COUNTY COUNCIL'S RESPONSE TO CONSULTATION ON THE FOLLOWING DEVELOPMENT PROPOSAL

Application No: 19/01410/REM

Proposal: Reserved matters to 18/01491/OUT - Application did not require an EIA. Seeking approval of layout, landscaping, appearance and scale. Access details approved as part of outline permission

Location: Cotswold Country Club, Bunkers Hill, Shipton On Cherwell

Drawing No.
392/19/PL1001
Revision
A

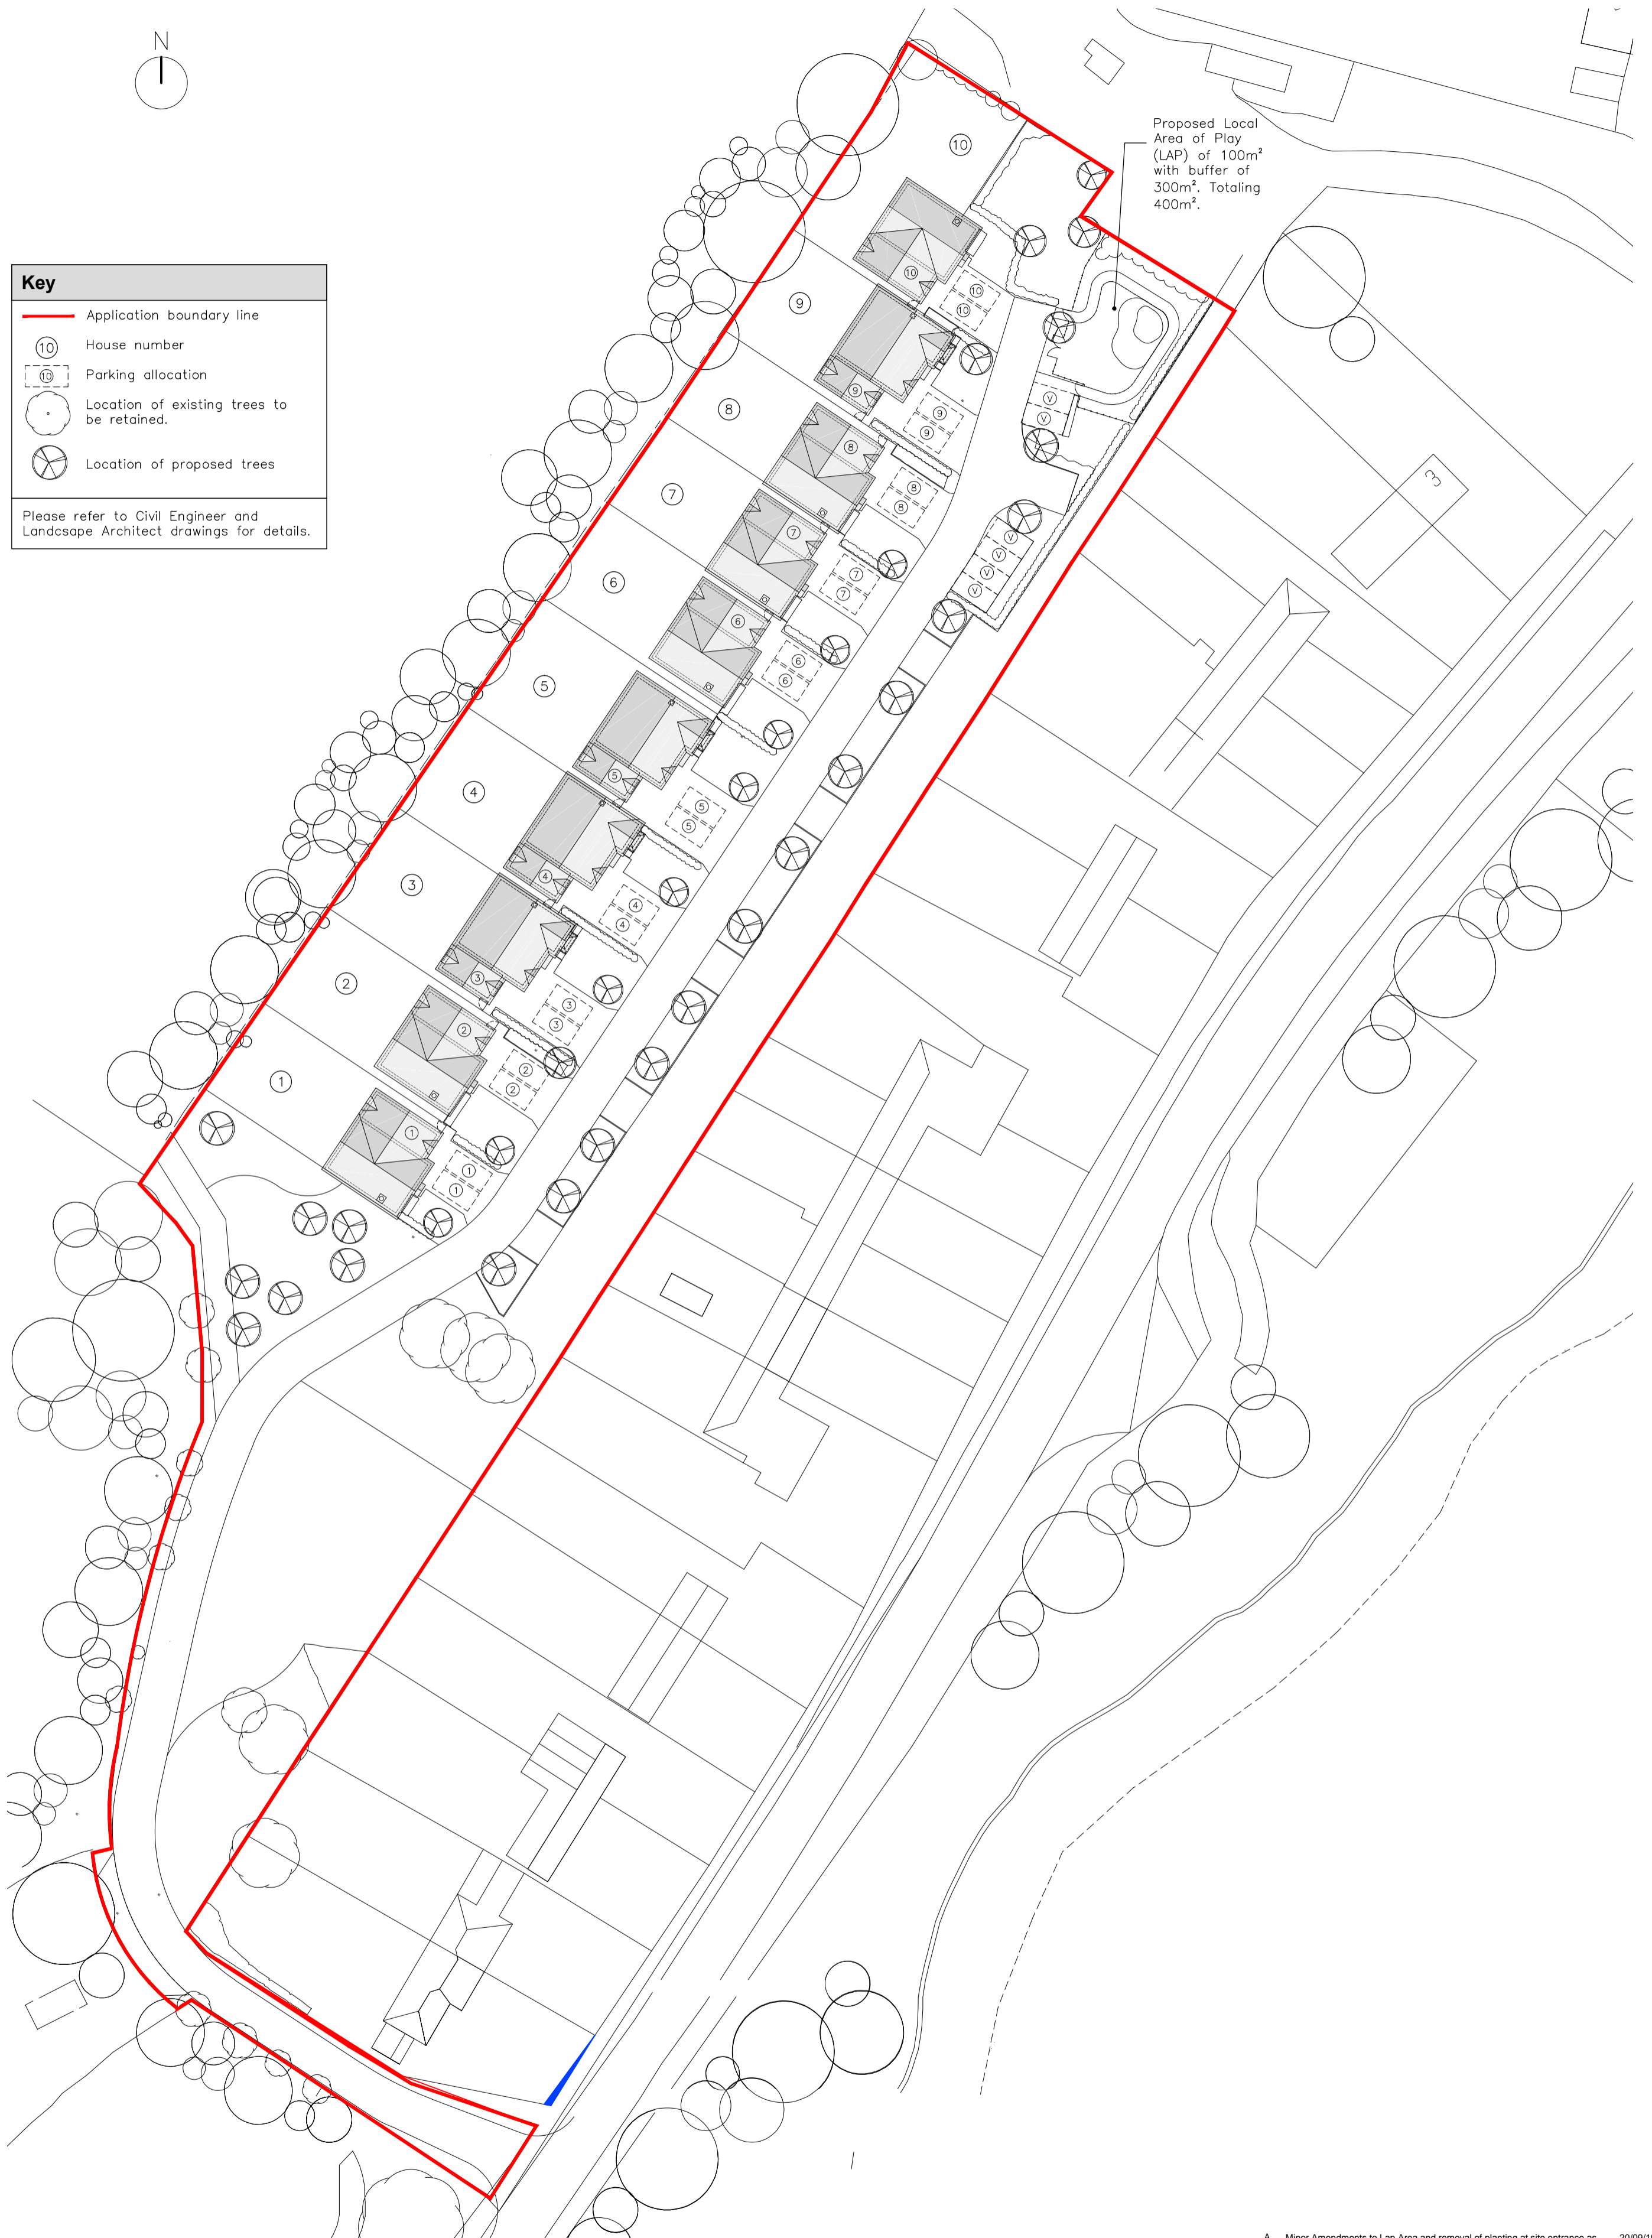
Tracking is required to demonstrate that a refuse vehicle of 11.6m can access, turn and egress in a forward driving gear from the site.

The proposed visitor parking bays are to be laid in gravel. This should be changed as gravel could out of the bays and be dragged onto the estate road. A solid surface is preferred to avoid this from occurring.
